WELWYN HATFIELD ACCESS GROUP
 the common room
 ground floor
 ley house
 long ley
 welwyn garden city
 hertfordshire al7 2ex

16 August 2014]

re: Planning Applications Received by Welwyn Hatfield Council

Application No.	Description and Location	Applicant/Agent
S6/2014/1696/FP	Erection of 4 detached dwellings with access from Kingsmead following demolition of 19 Kingsmead. Land at and to rear of 19 Kingsmead, Hill Rise and Plough Hill Cuffley, Potters Bar EN6 4AN	Mr M Lake DLA Town Planning 5 The Gavel Centre Porters Wood St Albans AL3 6PQ

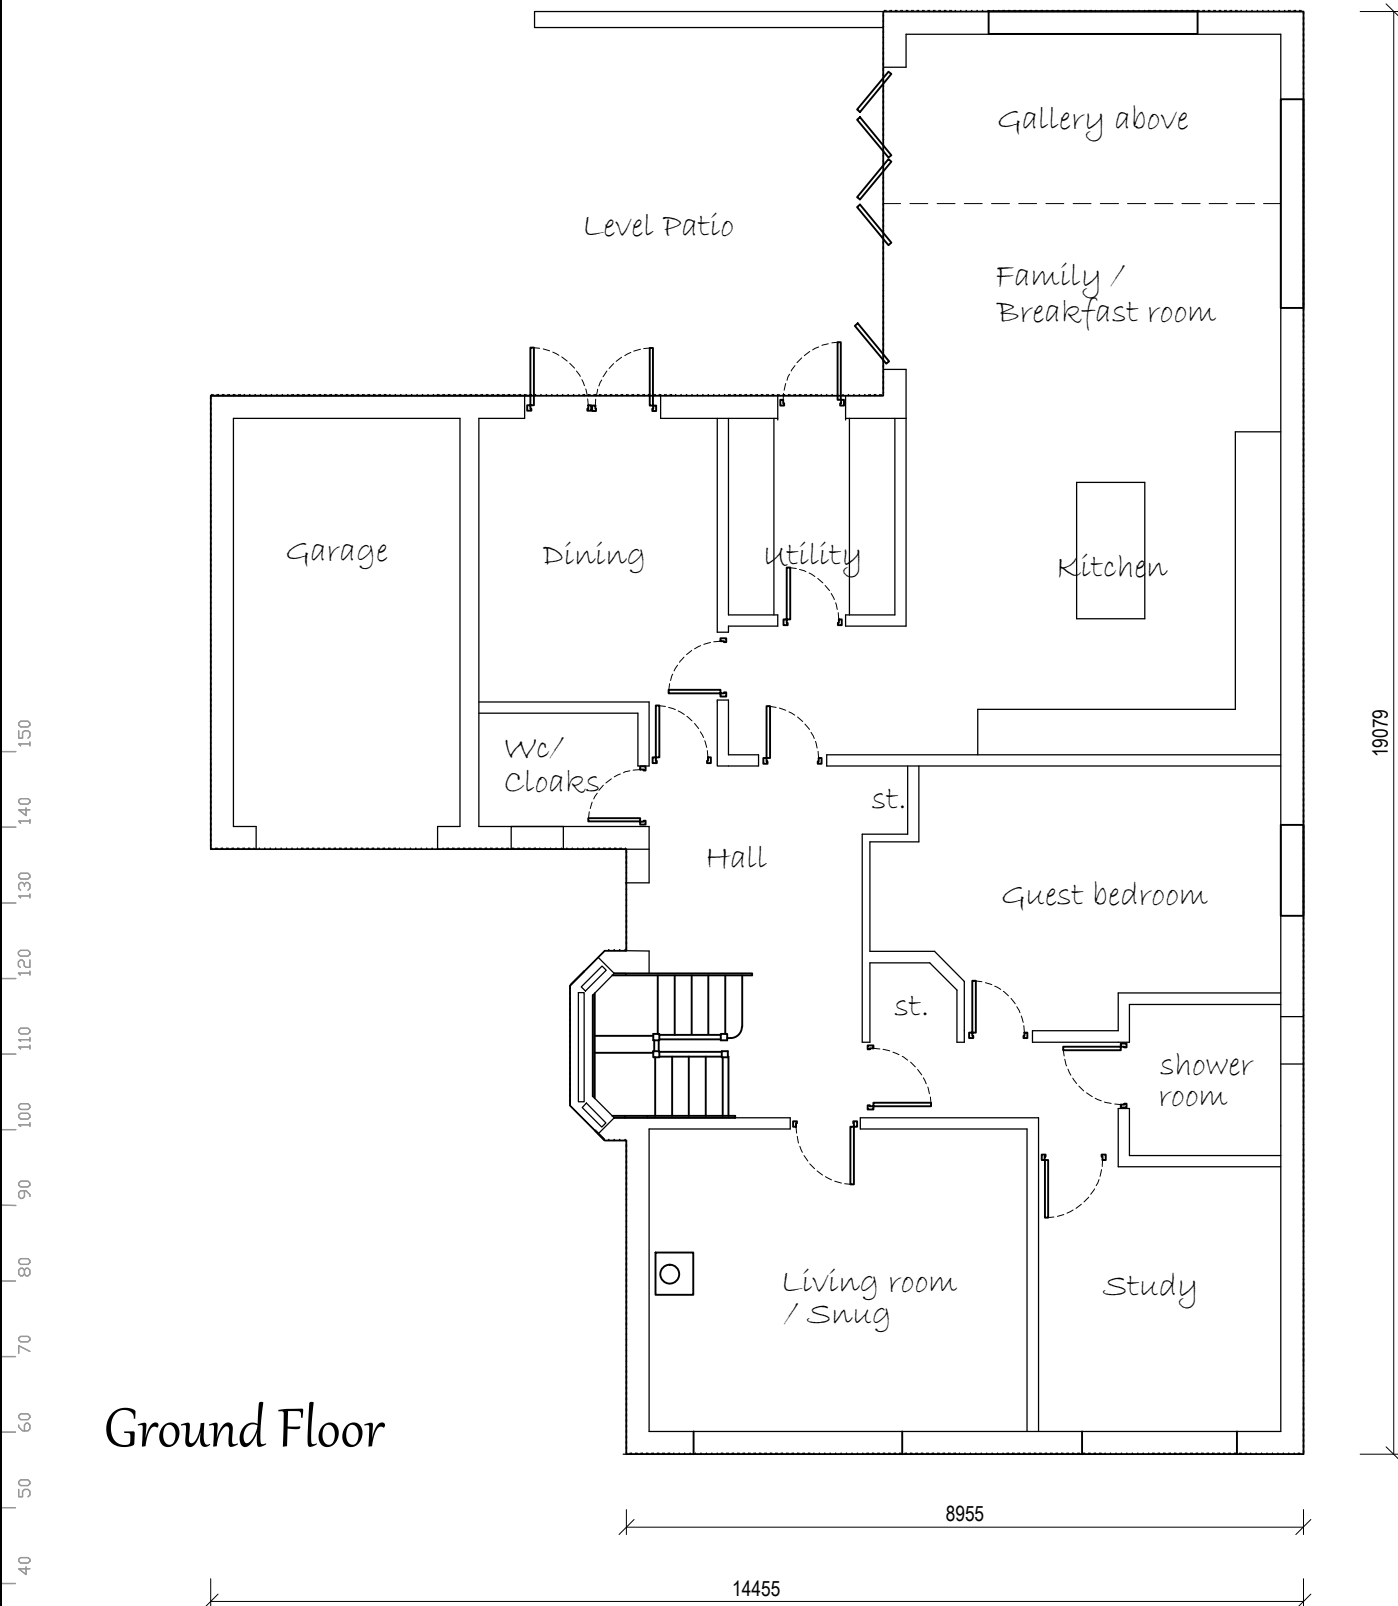
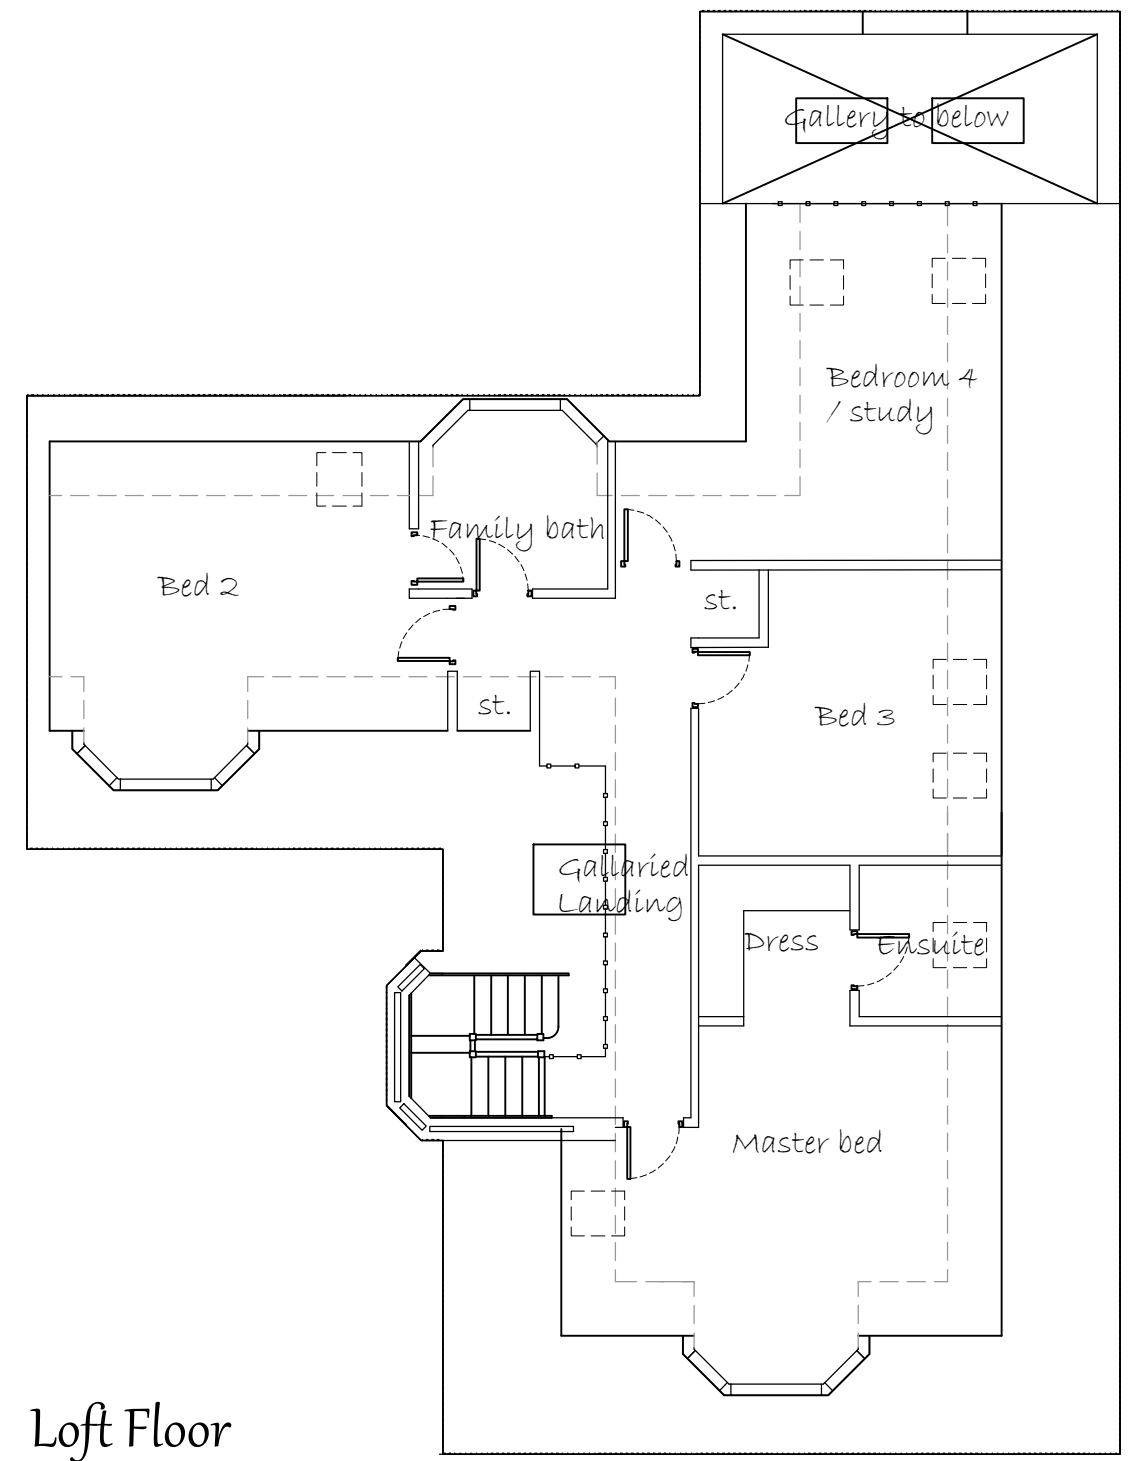
We note the provision of a ground floor wc/cloaks. We also note the inward opening door into this facility. Would it be possible to consider reversing this to an outward opening door to make it easier for disabled access?
